Appeal Decision

Appeal Ref: APP/R5510/W/23/3315337

139 Belmont Road, Uxbridge UB8 1QZ

- The appeal is made under section 78 of the Town and Country Planning Act 1990 against a refusal to grant planning permission.
- The appeal is made by NARRD Ltd against the decision of The Council of the London Borough of Hillingdon.
- The application Ref 17175/APP/2022/1989, dated 21 June 2022, was refused by notice dated 2 November 2022.
- The development proposed is the redevelopment of existing two storey dwelling, and the erection of 3 no. dwellings with associated private amenity space, car parking, bike and refuse storage.

Proposed Ground Floor Plan

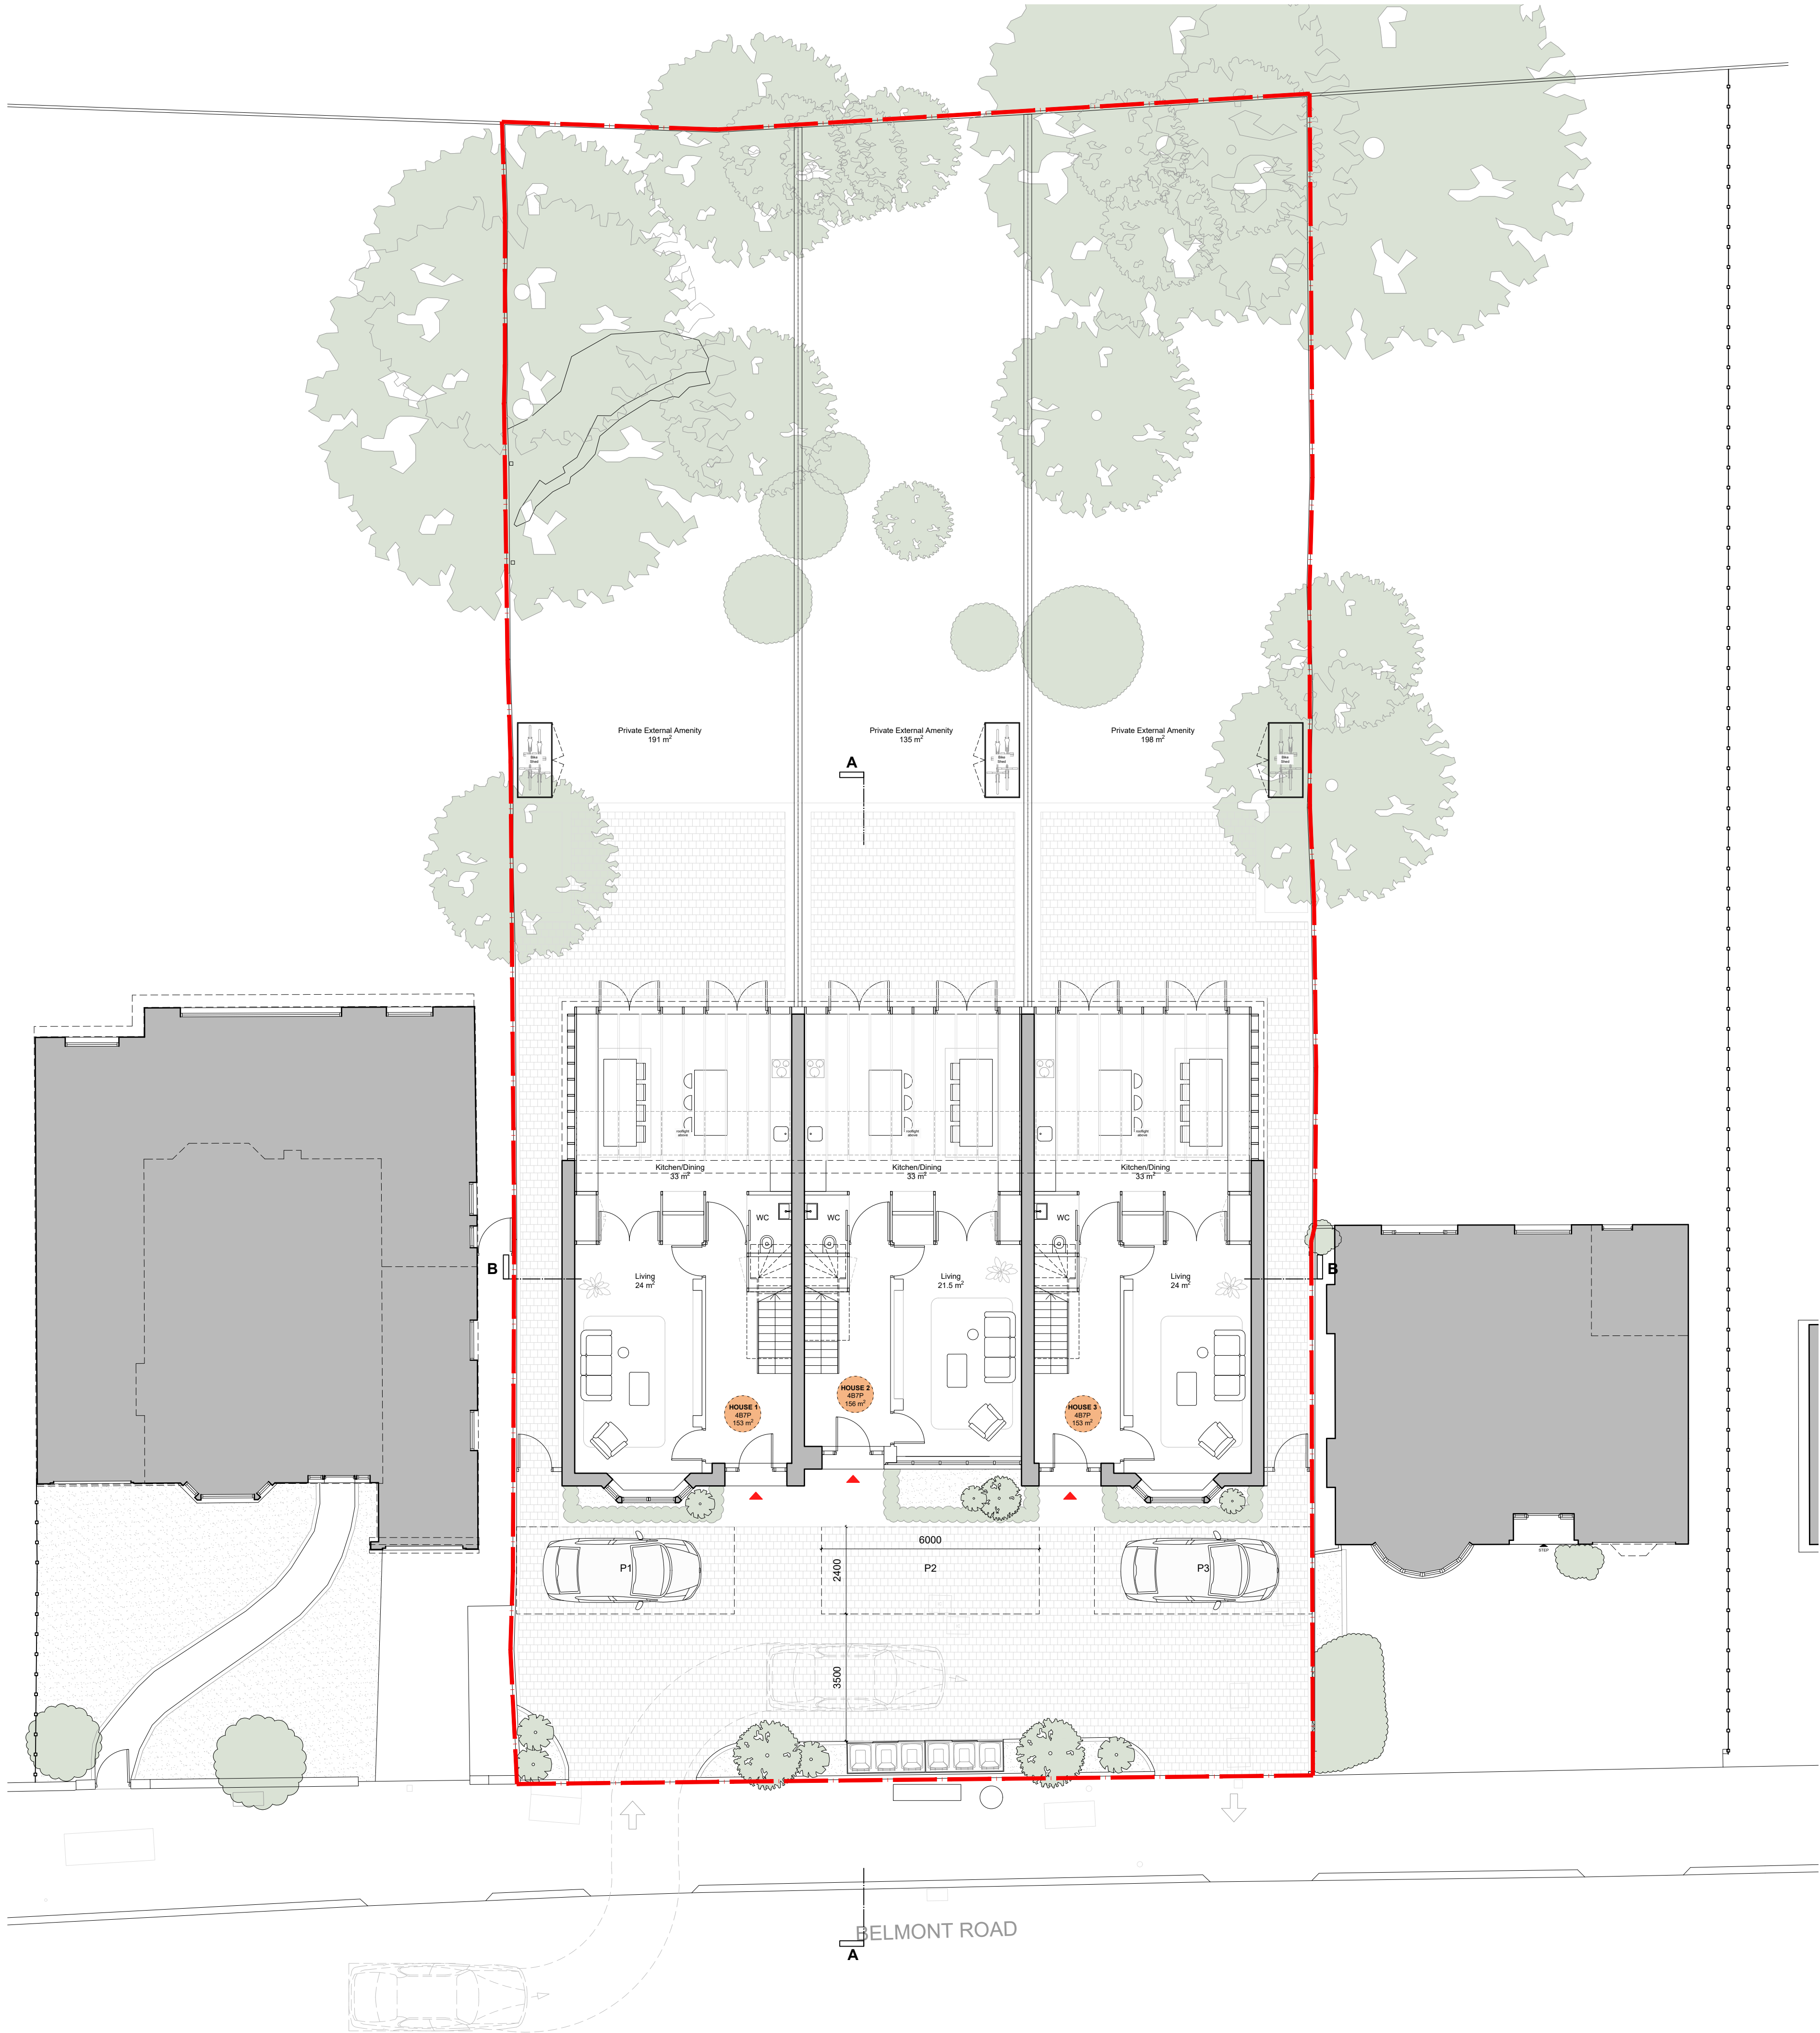
5. The proposal would result in the introduction of a block of 3 three-storey terraced dwellings. They would be set in by a small distance from the common boundary on either side. Due to its overall width, limited set in from the common boundaries on both sides and the overall building mass which would extend almost across the entire width of the plot, the proposal would appear unduly cramped on the site, would represent an over intensive form of

Existing & Proposed Street Elevation

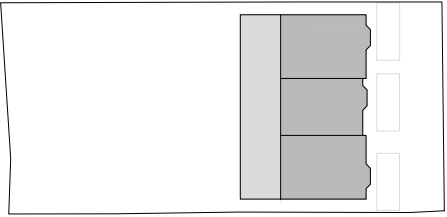
development that would not respect the existing pattern of development and would undermine the existing spacious character. As a result, the proposal would appear as a discordant feature that would look harmfully out of place.
